**Consultation Response from KC,
Highways Development Management****2025/92968 29, Huddersfield Road, Mirfield, WF14 8AE****Outline application for erection of residential development****Date Responded: 11/02/2026****Responding Officer: D. Stainsby****Responding Ref: K10-9NE/7****RECOMMENDATION:**

Project:
Residential Feasibility
at Old Water Hall
29 Huddersfield Road
Mirfield
for Mr & Mrs. Higgins
Access Layout

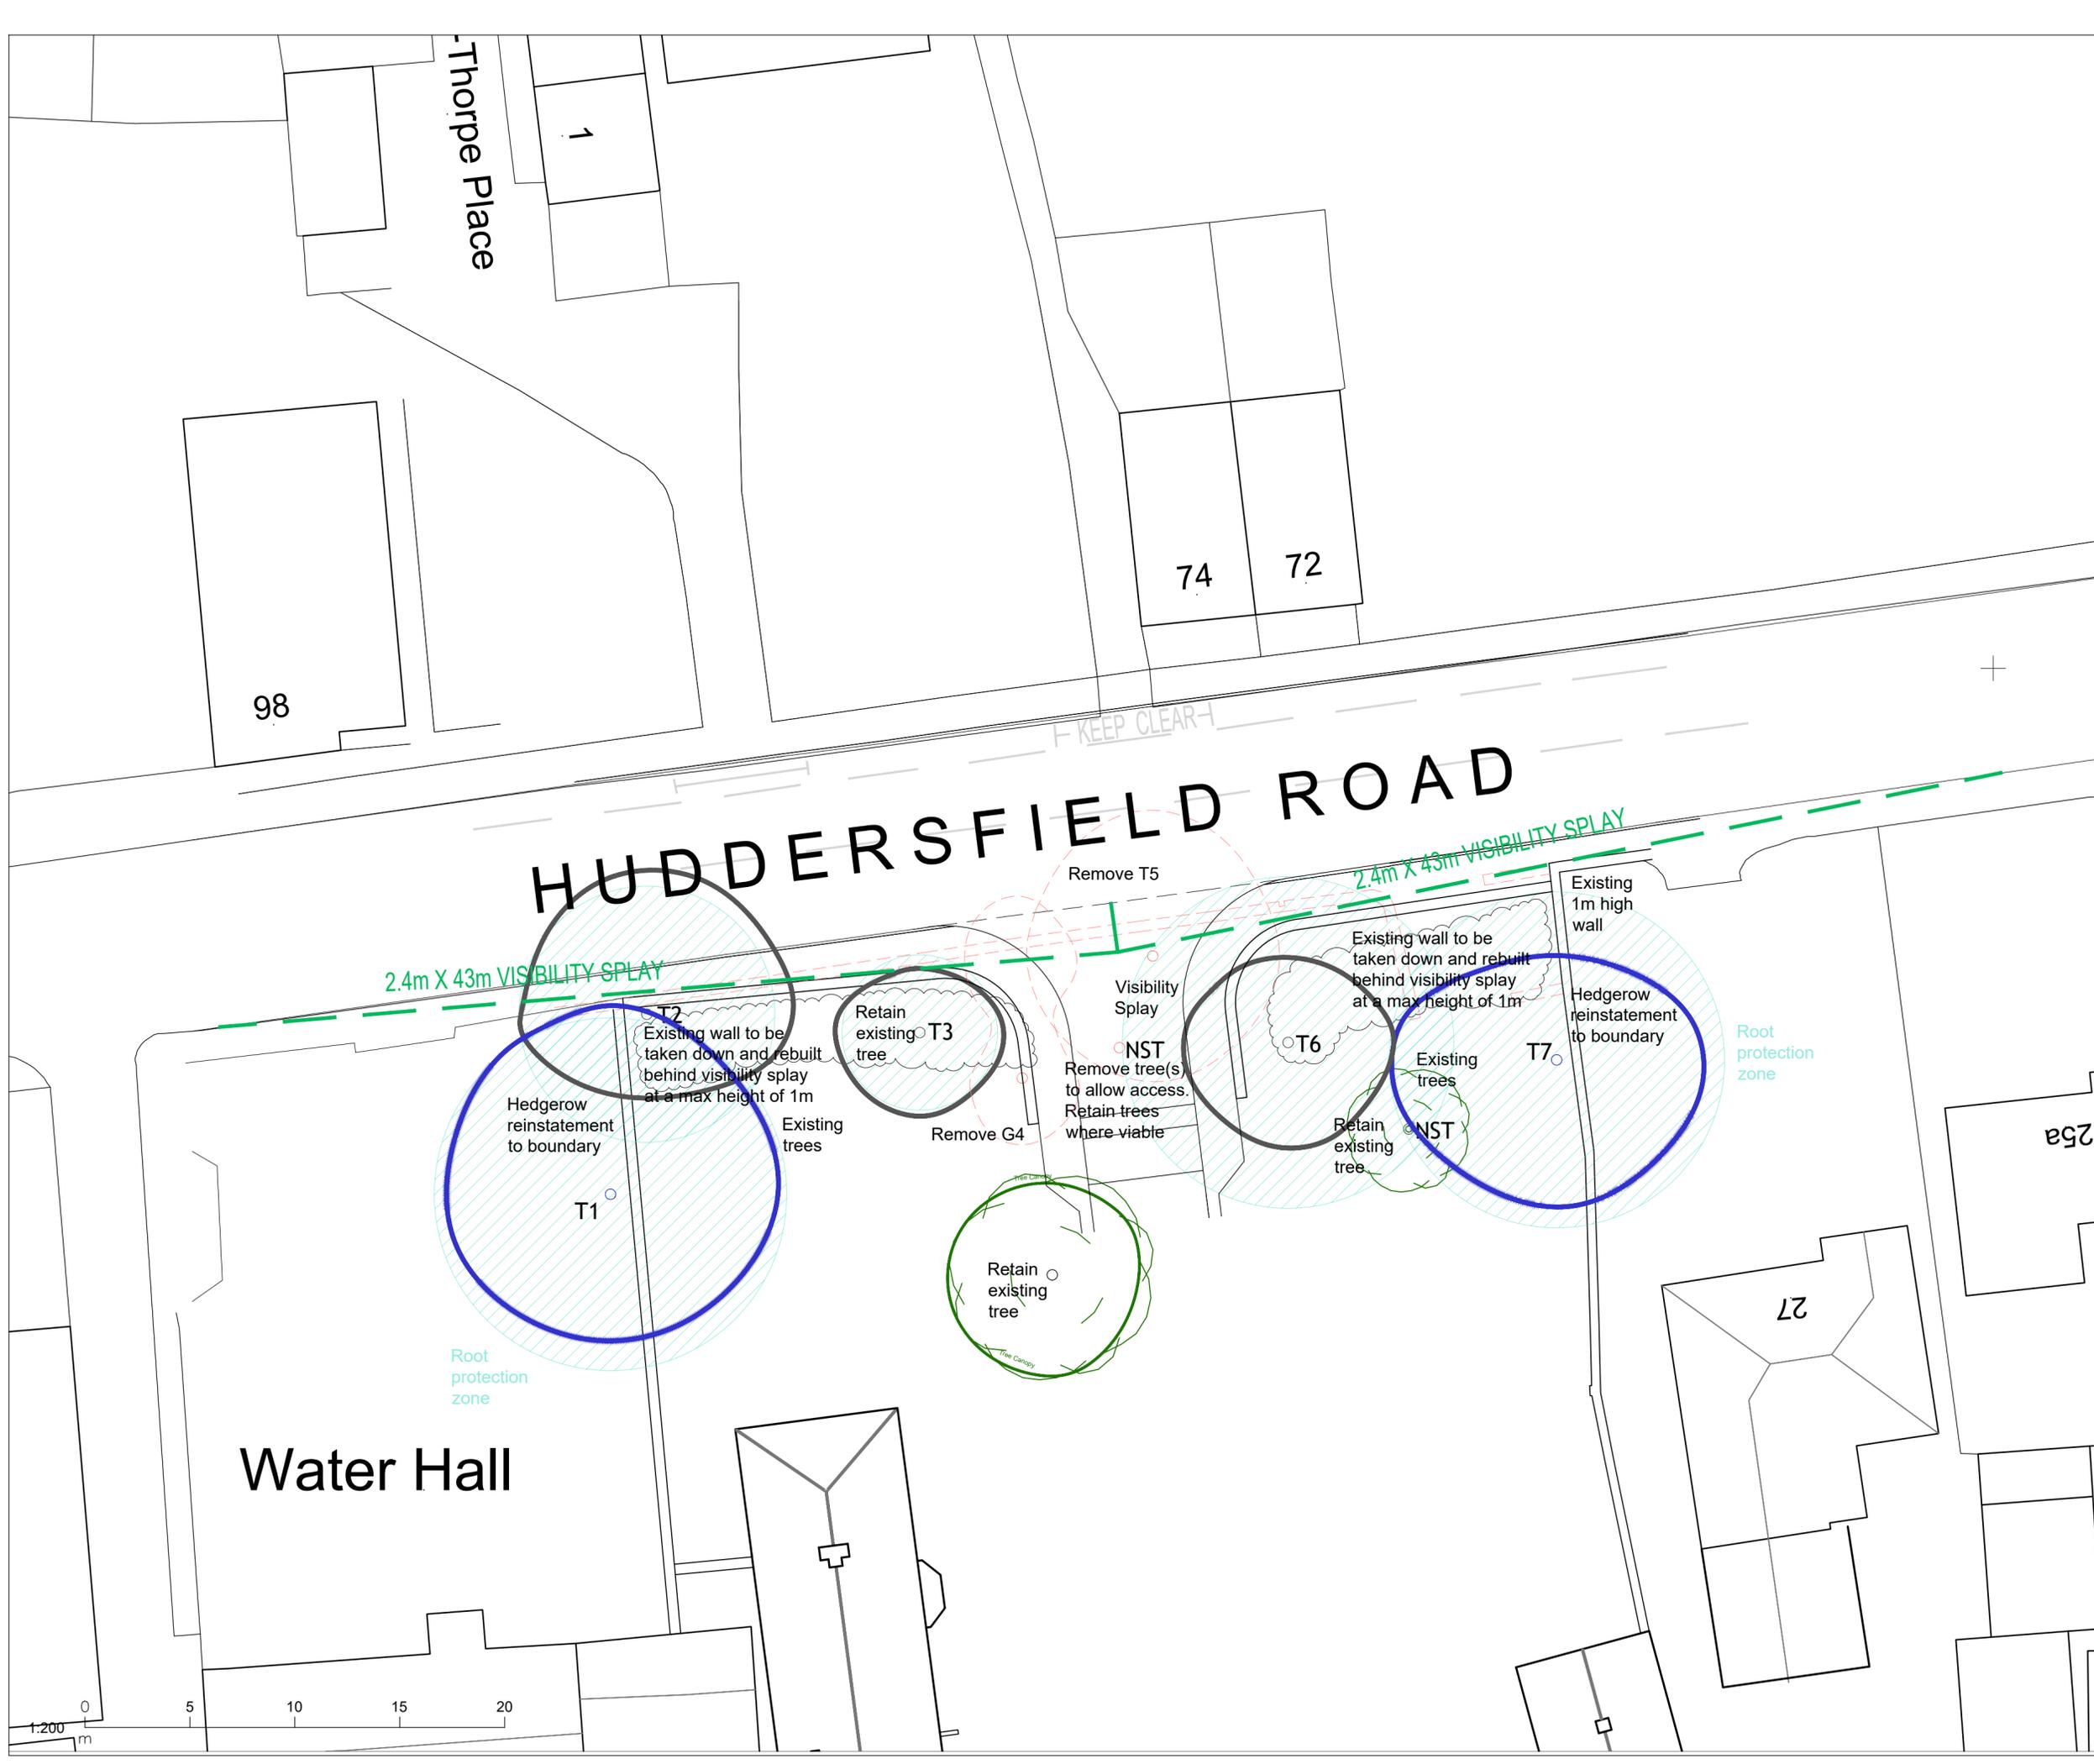
Confirmation that the required visibility splays can be met needs to be properly demonstrated.

The proposed site layout drawing shows the access relocated to the centre of the northern site boundary, with a 2m proposed footway along the site frontage. The proposed access is shown at 5.5m wide with 6m radii.

The footways along the site frontage continue around the proposed access radii and c.10m into site before transitioning into a shared surface arrangement with a 5.5m carriageway and 0.6m margins at both sides.

This meets the requirements recommended in the Highway Design Guide. However, at this location A644 Huddersfield Road has a cycle lane and parking bays on the opposite side of the road to the proposed access.

To ensure that turning movements do not encroach over the centre line of the main road the junction radii may need to be increased to 10m

VEHICLE ENTERING AND EXITING TURNING LEFT @1:500

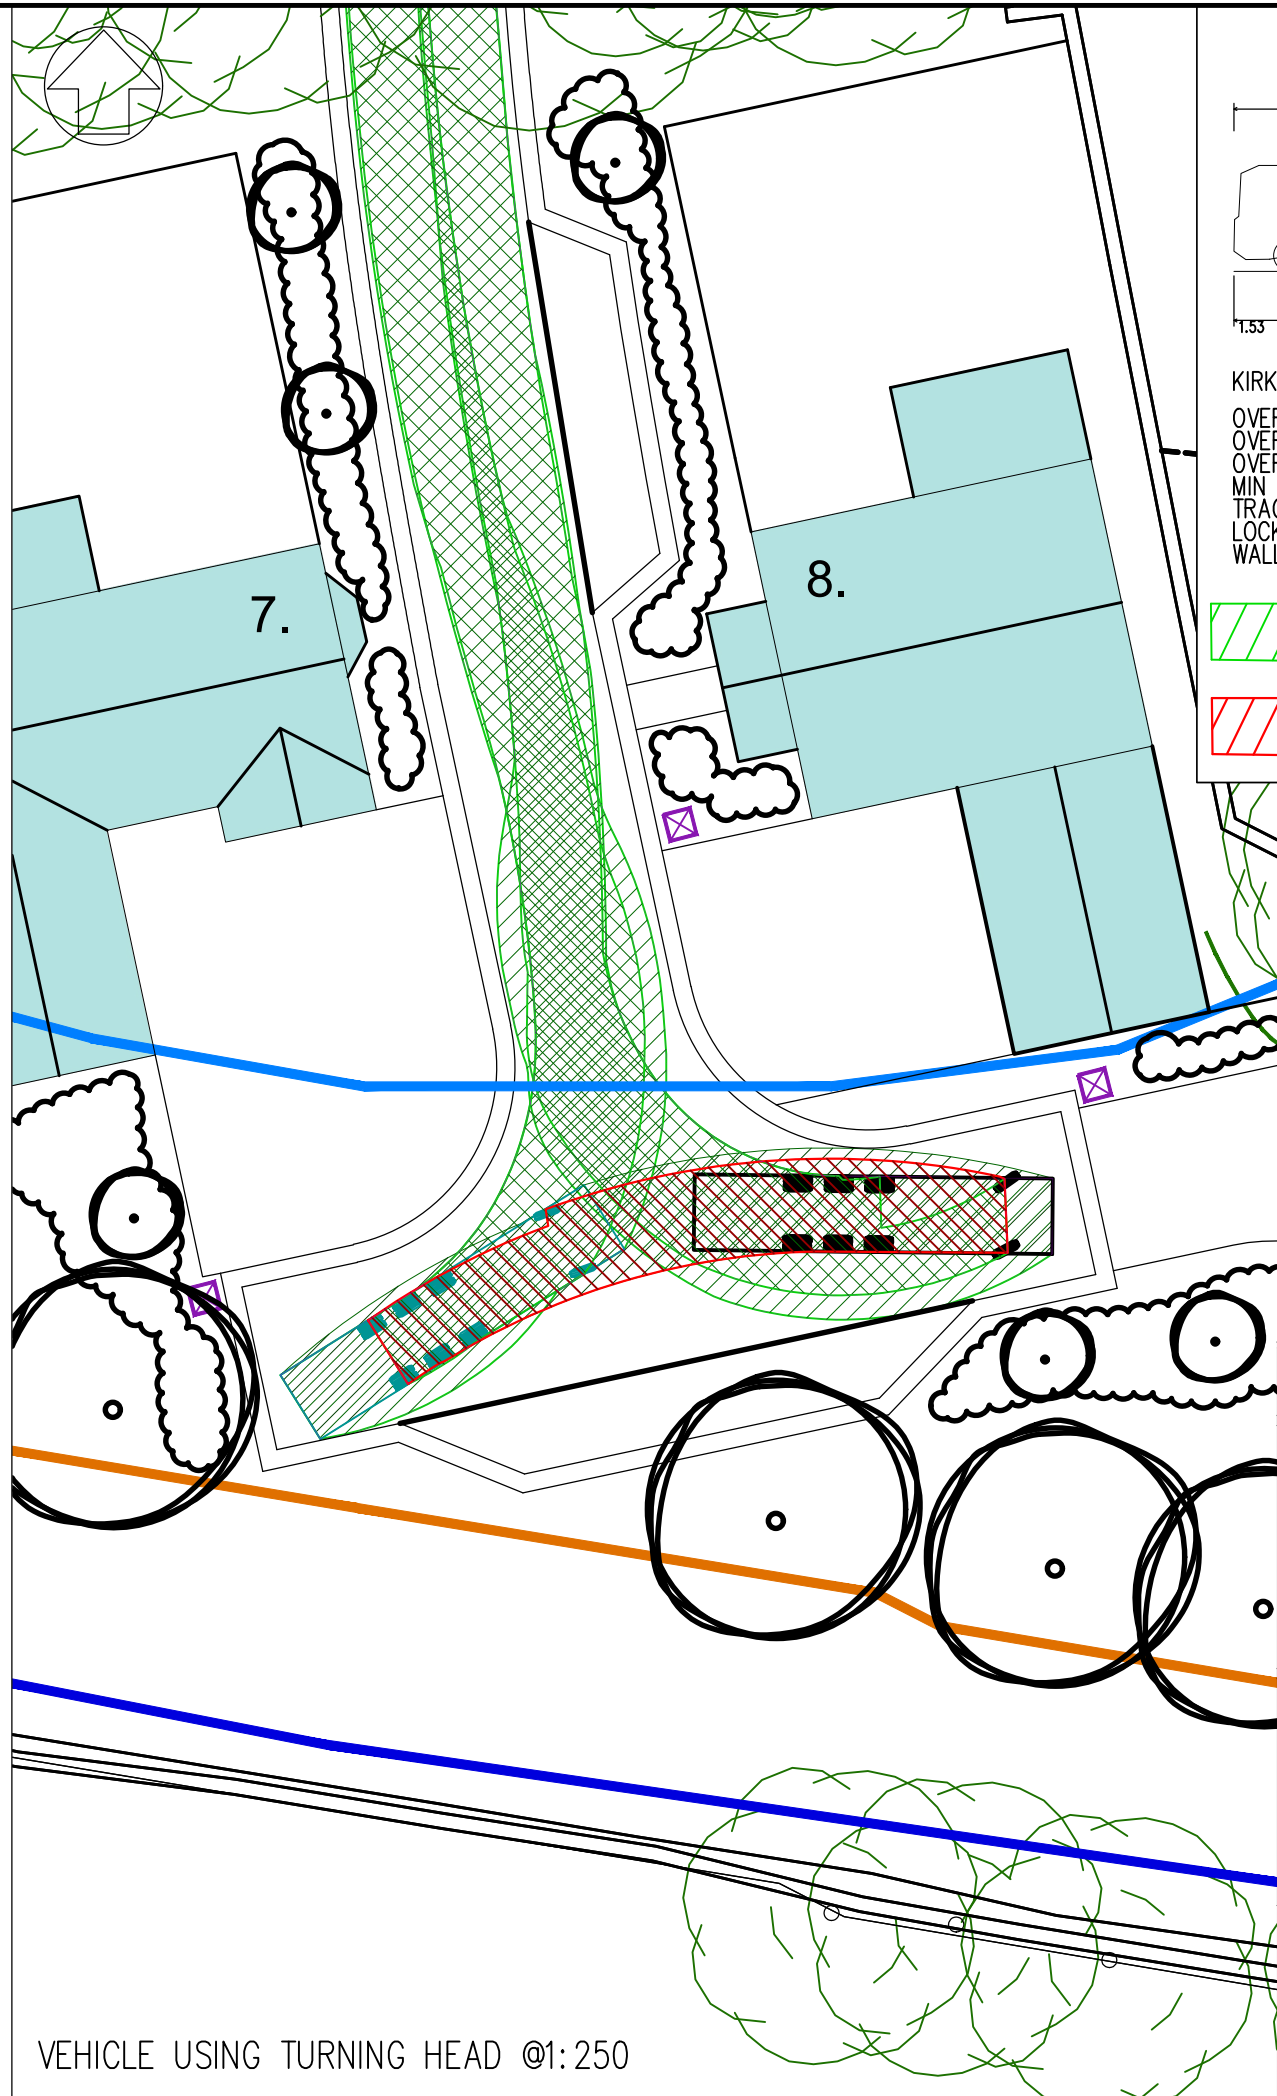
The swept path provided in the attached documents appears satisfactory. However, in order to check this point a Stage 1 Road Safety Audit is required prior to planning approval and in accordance with GG119 to help determine if these proposals are safe.
